**Application by Navitus Bay development Limited**

**Navitus Bay Wind Park**

**The Examining Authority's second written questions and requests for information**

**Issued on Wednesday 14 January 2015**

Figure 2. Contour plot showing the predicted 90 and 75 dBht effect ranges for salmon during the installation of 8m and 3.5m piles in the northern most positions⁴.

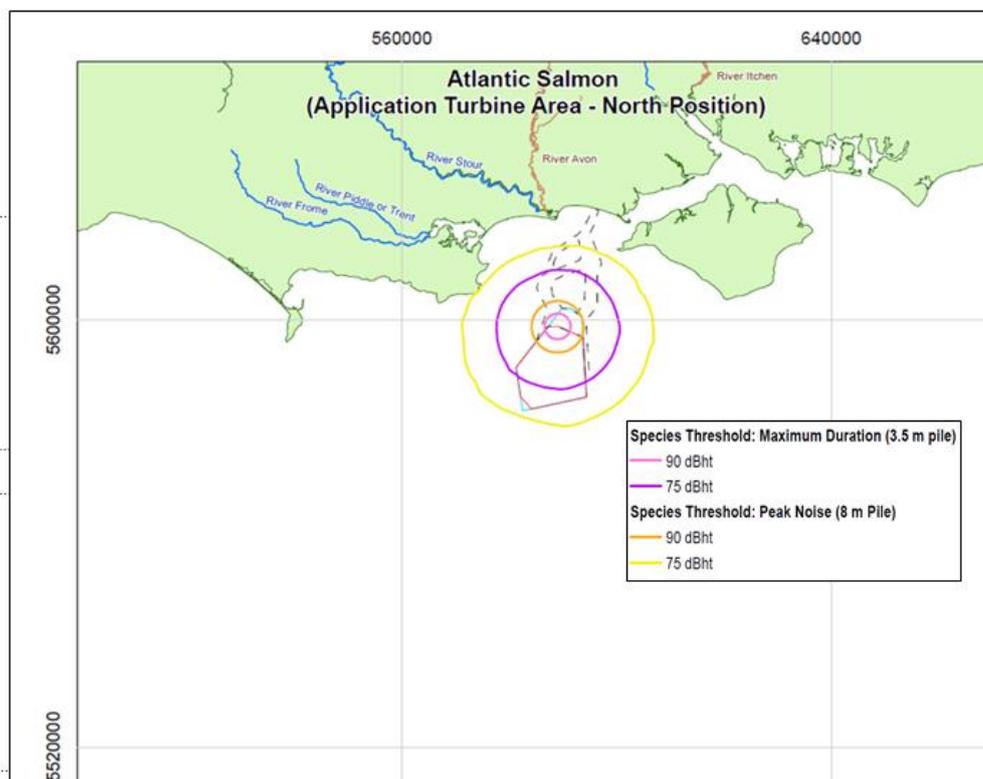
| <b>Question to:</b> |   | <b>Question</b>   |
|---------------------|---|---|
| 1.1.                | Environment Agency, Applicant                           | Salmon migration piling restrictions - can the Environment Agency share with the applicant the model used to estimate noise exposure risk, to assist in bringing closure to adult salmon mitigation?  |
